Engineers Comments Regarding Surface Water Drainage

Application Reference:	BE/146/25/DOC	Reviewer Reference:	ADC/EXT5/AF
Planning Officer:	Amber Willard	Date of Review:	19/02/2026
Site Name:	The Cottage Shripney Road Bognor Regis PO22 9PA		
Application Description:	Approval of details reserved by condition imposed under BE/176/21/PL relating to condition 26-surface water drainage.		
Assessment Number:	2

Comment 2: Flow control device evidence.

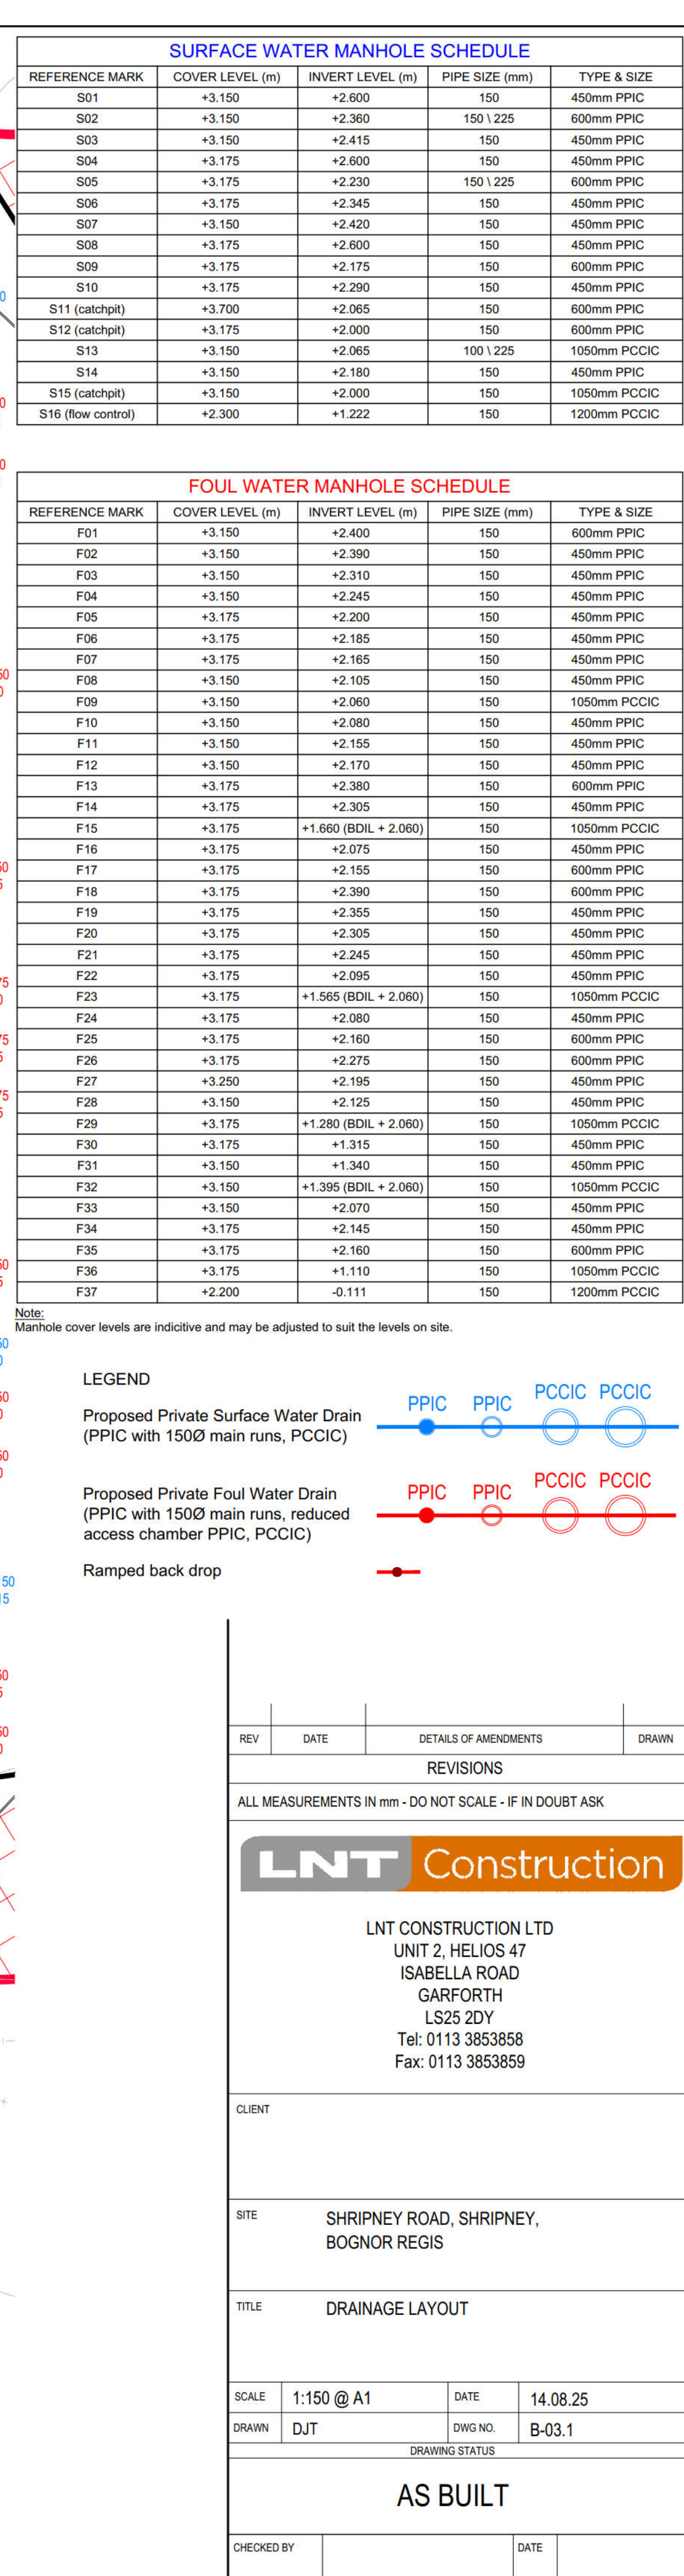
2.	The Flow control device should be evidenced to be installed in accordance with the approved plans including	Please see attached the as-built drainage survey which shows all of the schemes details and the fitment of the	In addition to the as built plan please provide evidence in the form of photos and records

IL, type and product reference.	model/type and invert at the flow control manhole (S17). The drainage has been installed as per the spec, apart from some small alterations to the north with the inclusion of the land drain and resultant impact on some inverters in the area. The information on the as-builts shows the flow control unit, the specification as installed and the invert	particularly the flow control product including orifice size and depth to IL as the two main criteria controlling peak flow.
